REFUSAL OF PLANNING PERMISSION

APPLICATION NO. 2019/0511

Proposal Change of use to 7 bedroom house of multiple occupation (Sui Generis Use Class)

At 215 Sheffield Road, Barnsley, S70 4DE

PROPOSED PLANS

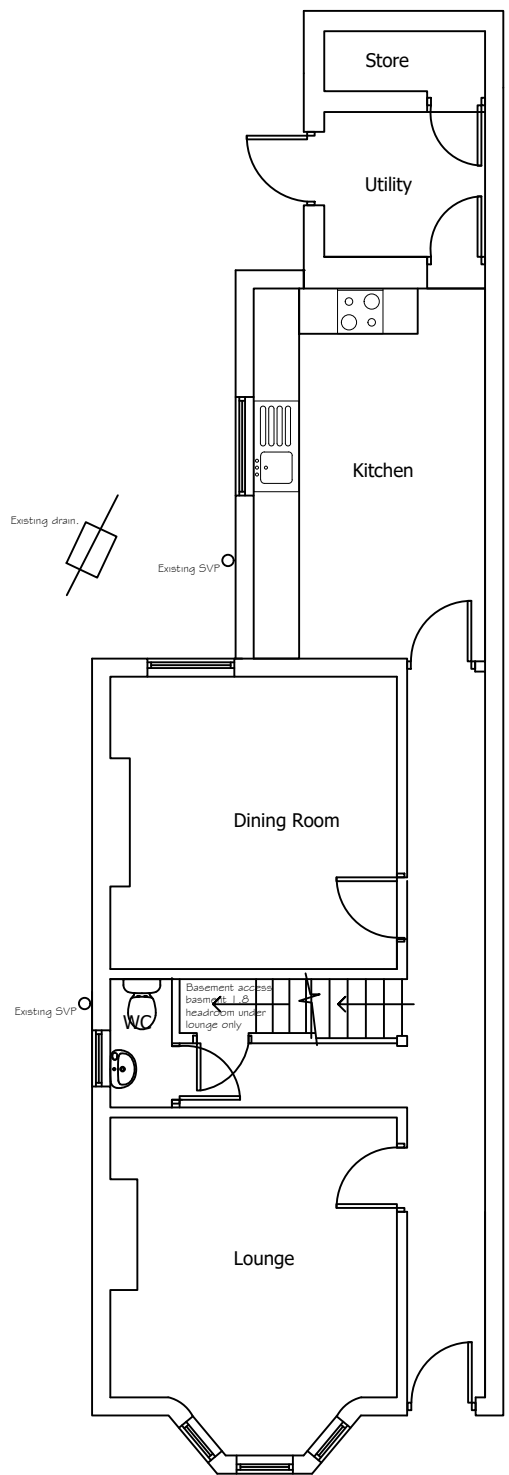
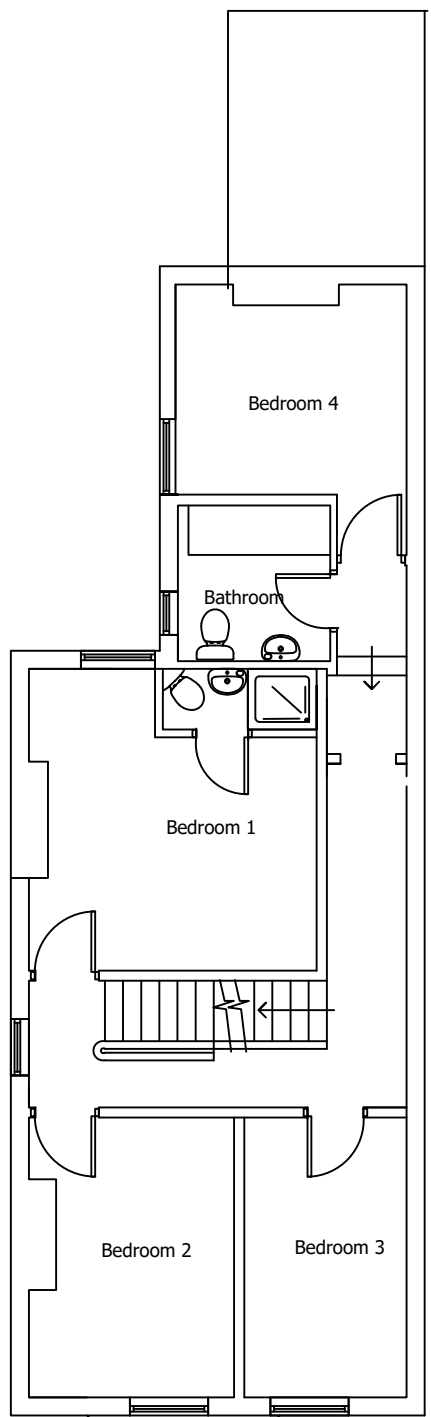
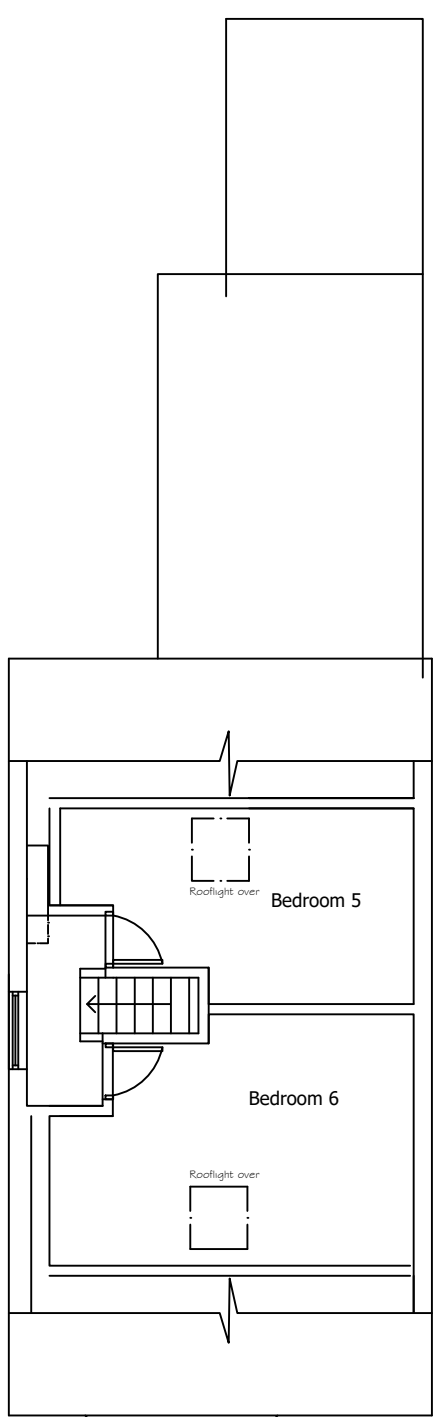
- 1 In the opinion of the Local Planning Authority the proposal would lead to the loss of a shared dining room at the expense of an additional bedroom. The provision of 7 bedrooms within this HMO is excessive and this would also mean that the development would fail to provide both a shared lounge and shared dining room. As such the proposal would be contrary to the Council's 'Design of Housing Development' and Local Plan Policy GD1 'General Development' as it would have an adverse effect on the living conditions of existing and future residents.
